# WATERLOO METRO QUARTER BUILDING 3&4

SSD-10437 - RESPONSES TO DPIE

PREPARED FOR WATERLOO DEVELOPER PTY LTD  
DOCUMENT NO. WMQ-BLD34-BSA-AR-RPT-DA211

Date of Issue 04.06.2021

General Arrangement Plan
Level 24 (Plant) Plan

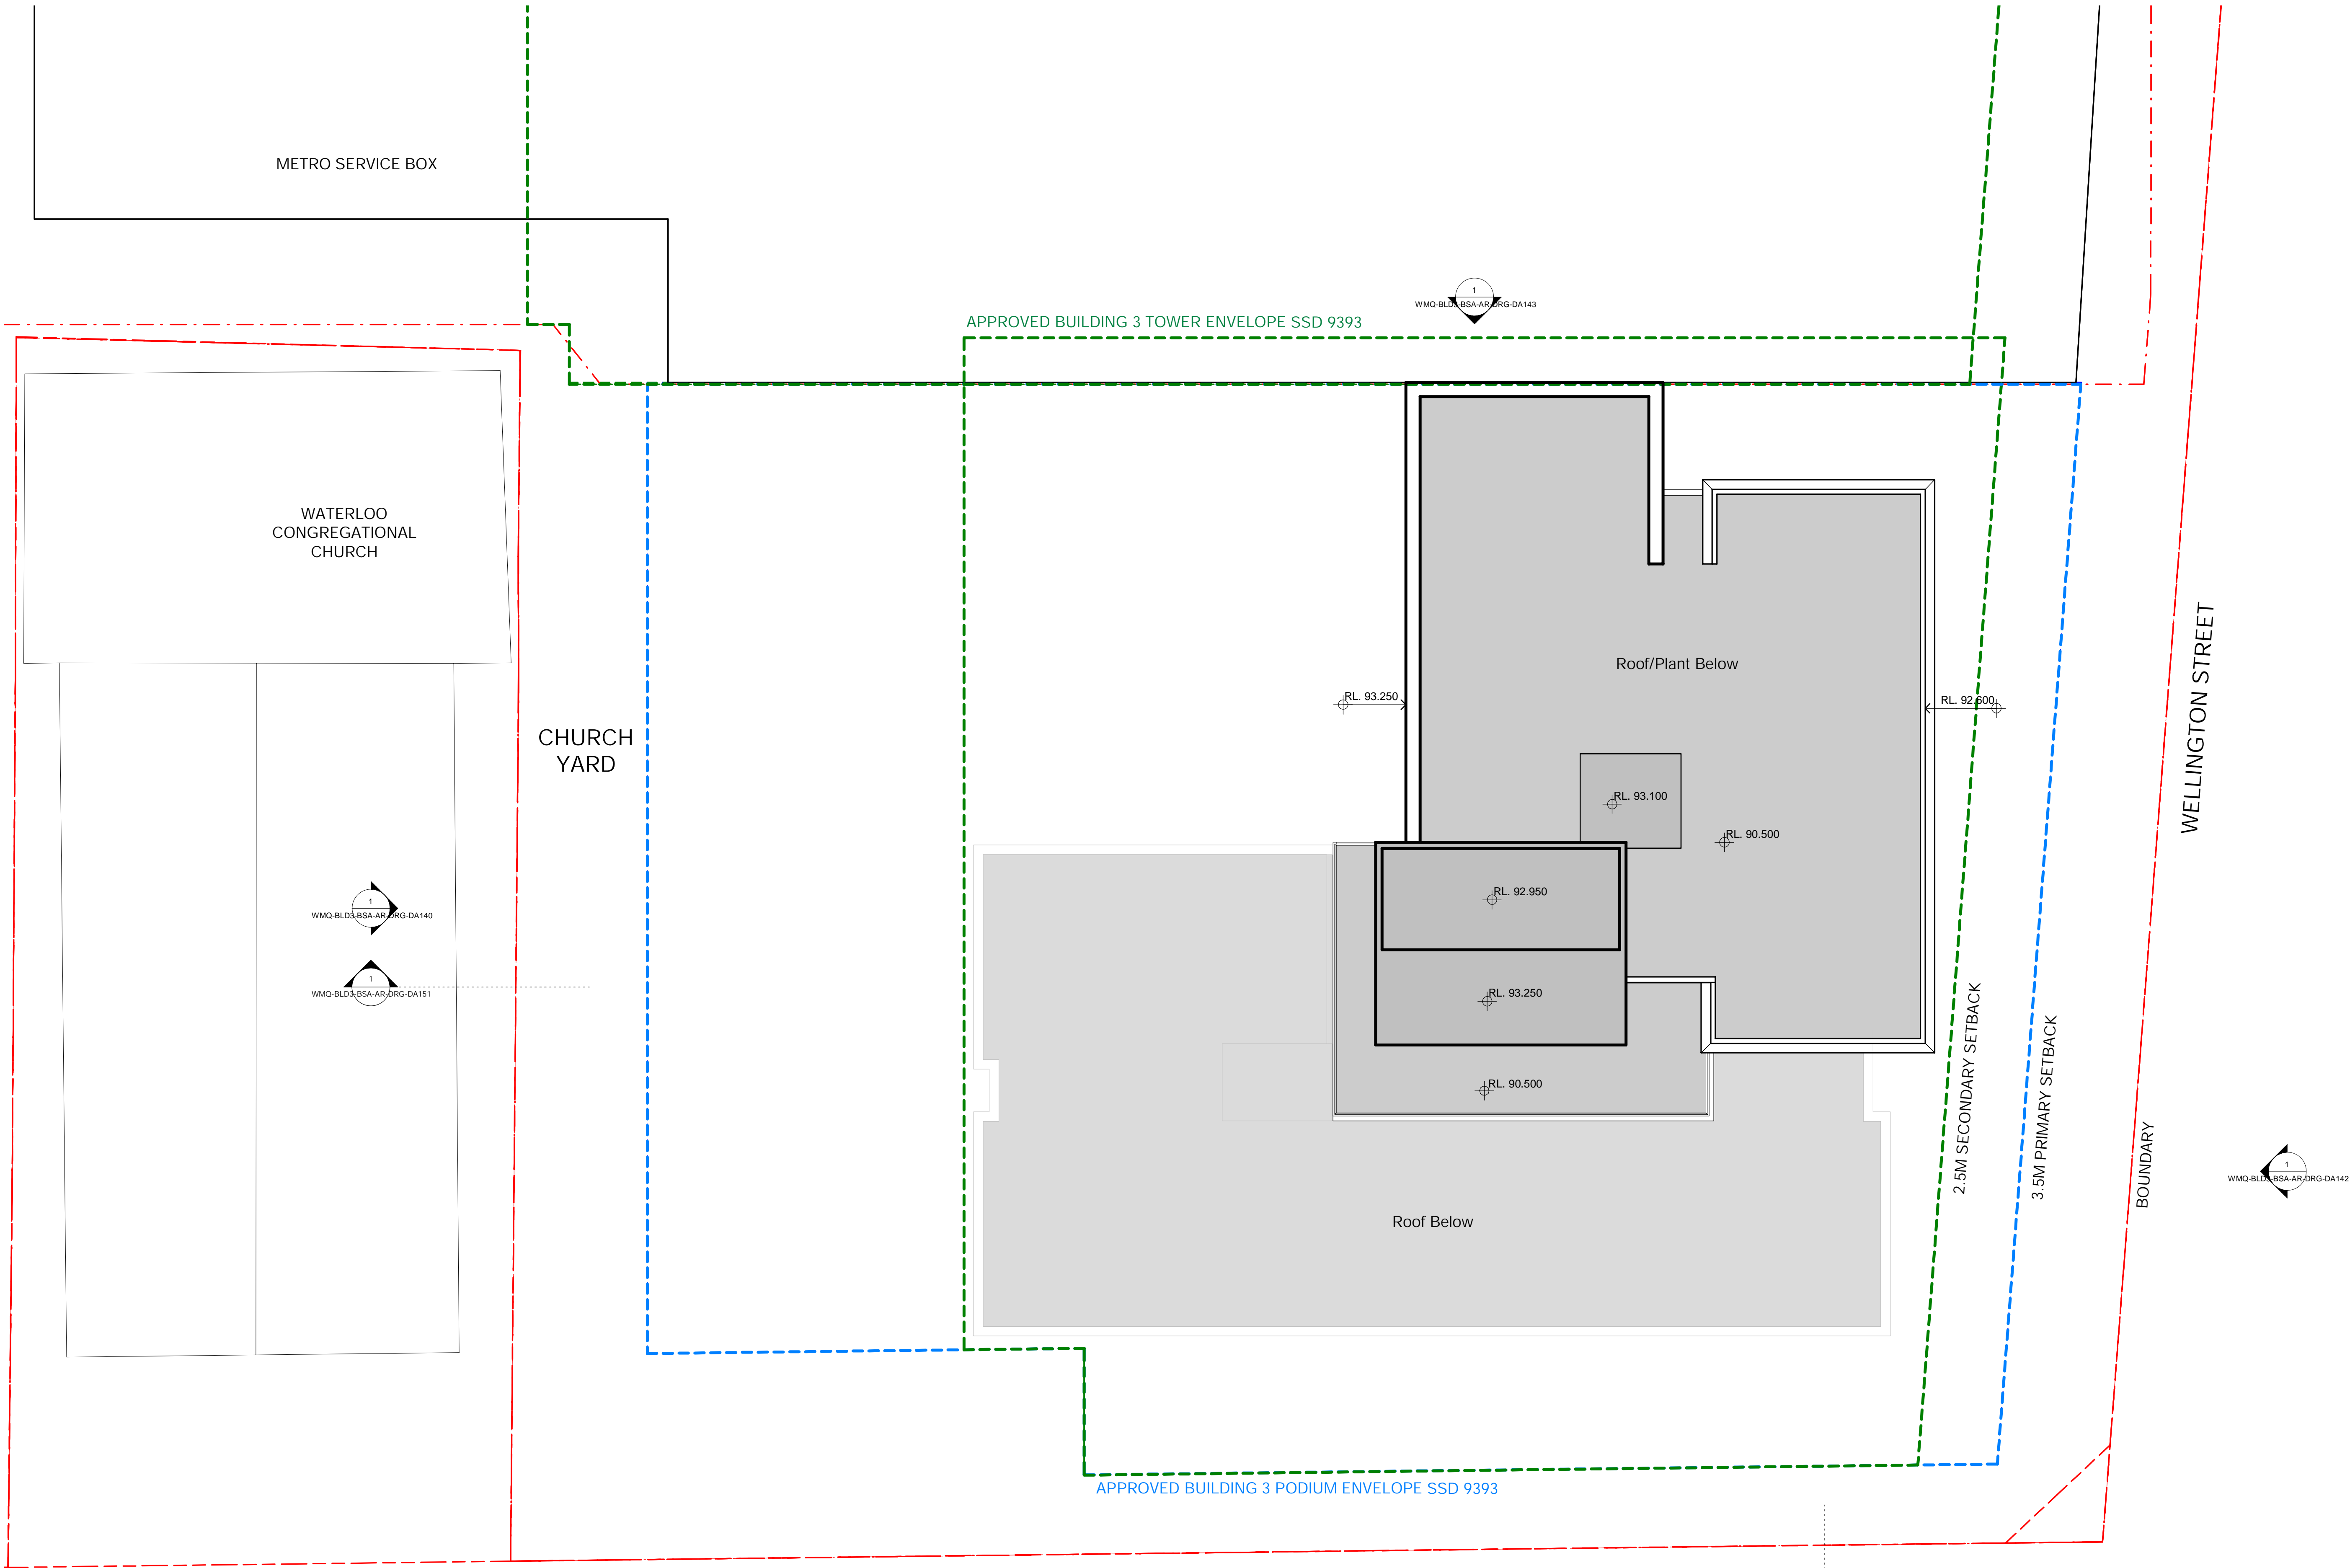
The height of the parapet on Building 3 identified in the image below should be extended from RL 87.35 to RL 88.9 to conceal views of the solar panels from the surrounding area whilst allowing for unobstructed solar access. All other parapets should be raised to a minimum 1.5 metres above the corresponding finished roof level, subject to mitigating any overshadowing impacts on Alexandria Park.

The height of the current Building 3 parapet is designed to minimise overshadowing of Alexandria Park. Any additional height along the building edge above that shown in the SSDA drawings will increase overshadowing to Alexandria Park.

To mitigate visibility from the surrounding area, the solar panel zone is proposed to be adjusted by reducing the overall maximum height from 1.5m to 1m, and increasing the setback to the north, south and east. The diagram on the right illustrates the revised extents.

Given the revised setback and height of the panel zone, the proposed panels are not expected to be highly visible from the surrounding streets. Refer to the images on the following slides for view impact studies from the surrounding area.

Elevation - North

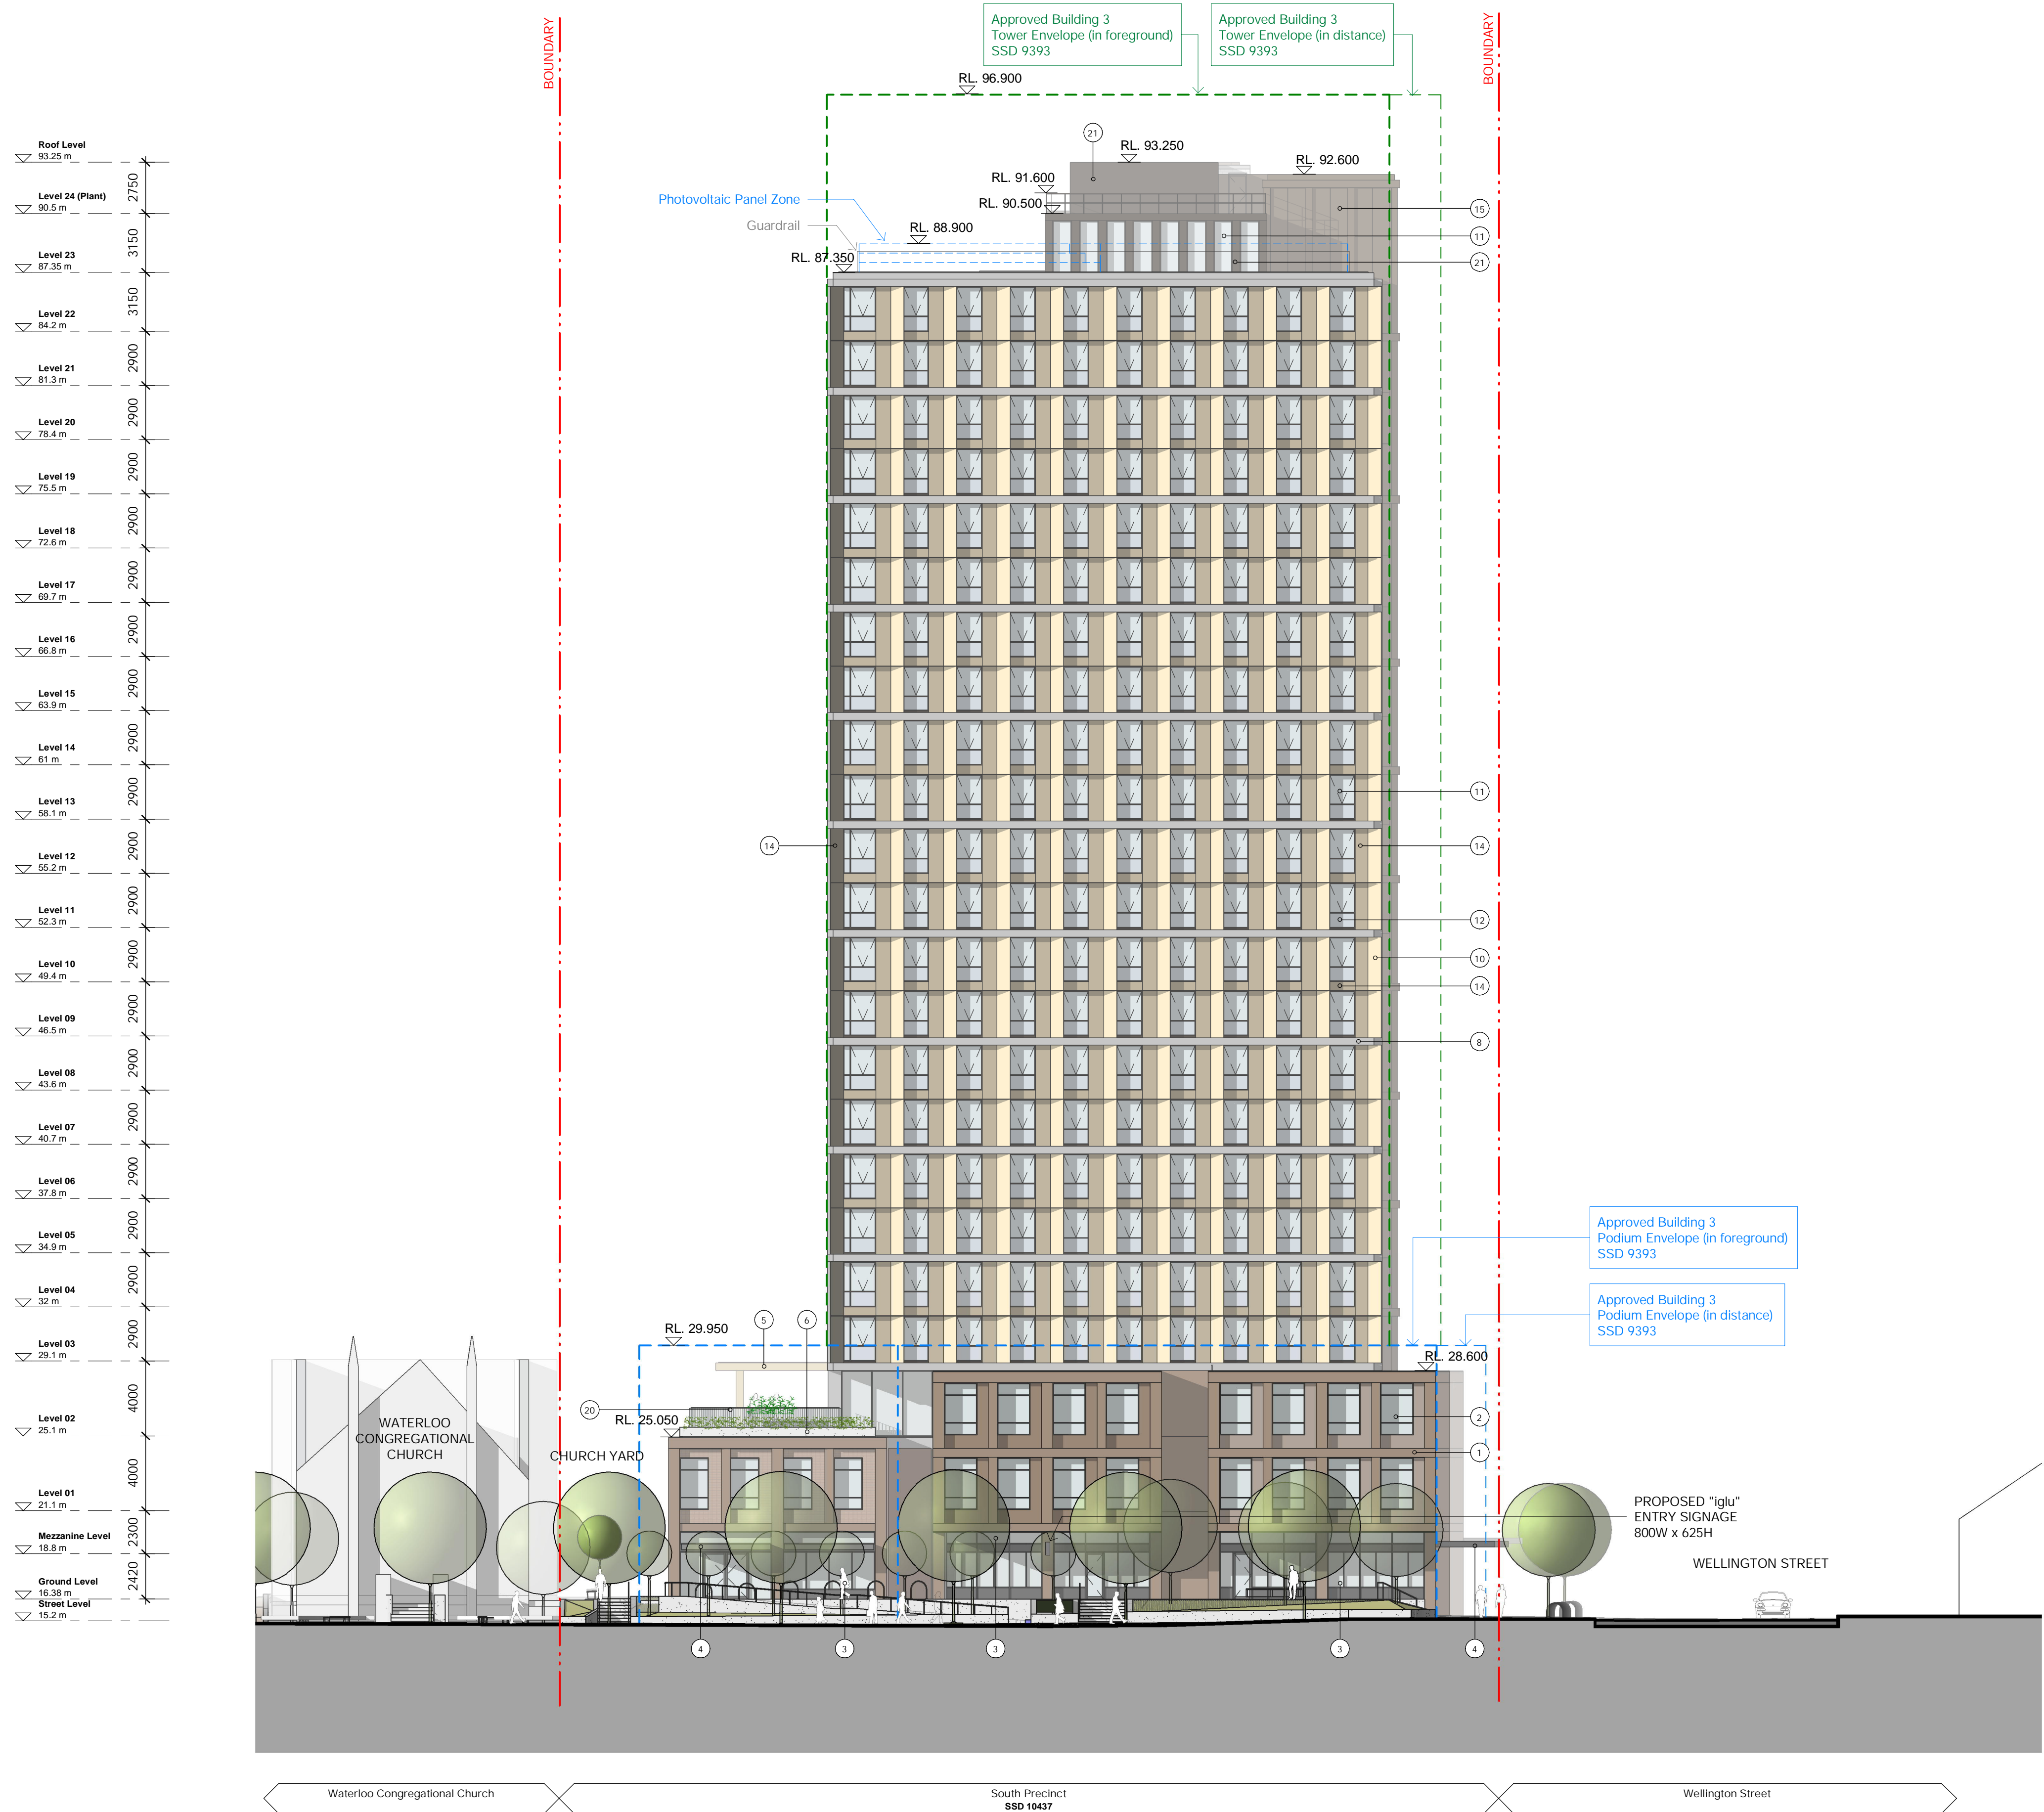
The additional glazing is acceptable, however, there is no variation in the colour of the grid and infill panels of the north or east walls. This monotony could be better treated with some variety in colour. A condition to this effect is recommended.  
(City of Sydney)

The design of the building ends have been developed in response to feedback from the DRP to ensure the facade design to these elevations are highly considered.

We believe the proposed design has a considered balance between built form articulation, fenestration and architectural expression through the expressed grid frame.

We have avoided pattern making through a variety of panel colours, instead favouring a more simple, elegant approach in keeping with the overall building architecture.
